# Rezoning Transportation Analysis

Petition Number: 2023-092

Date	Description
9-28-23	First Review (NK)
11-27-23	Second Review (JP)
1-24-24	Third Review (JP)

REZONING CASE #: RZP-2023-092

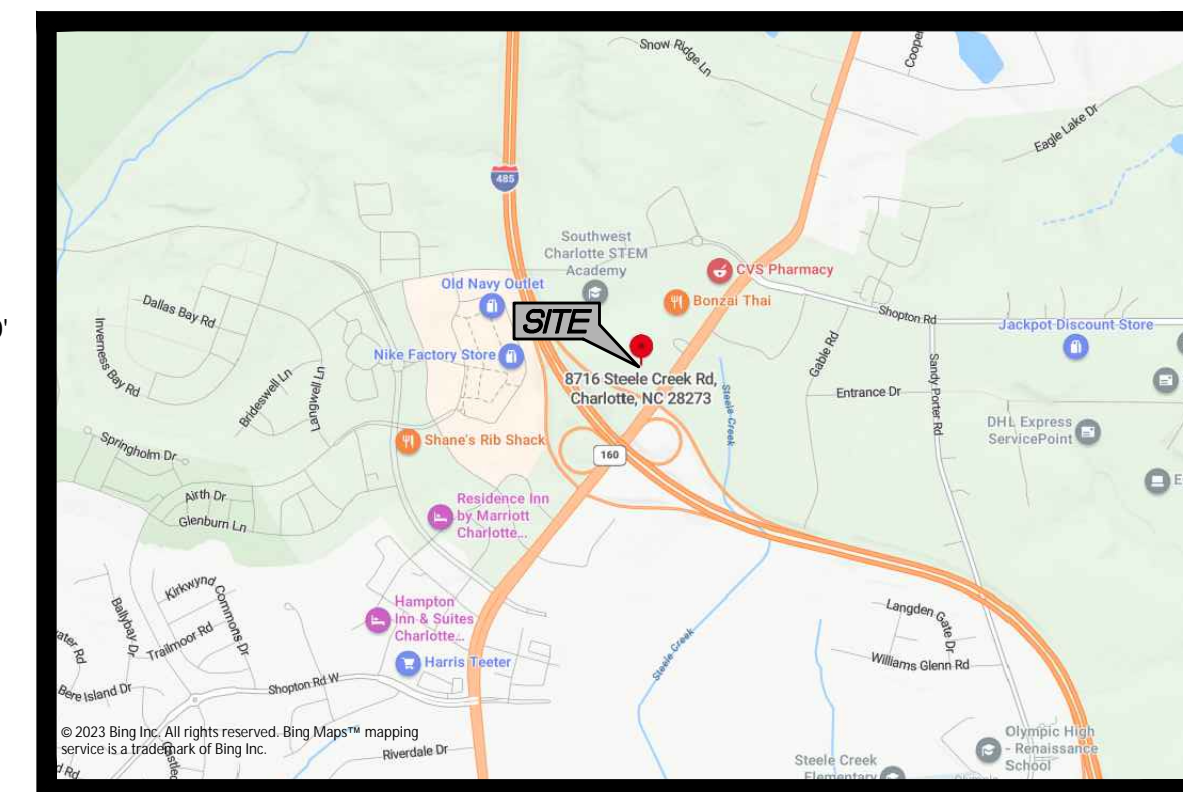
7. Revise site plan to align the sidewalk across the driveway.
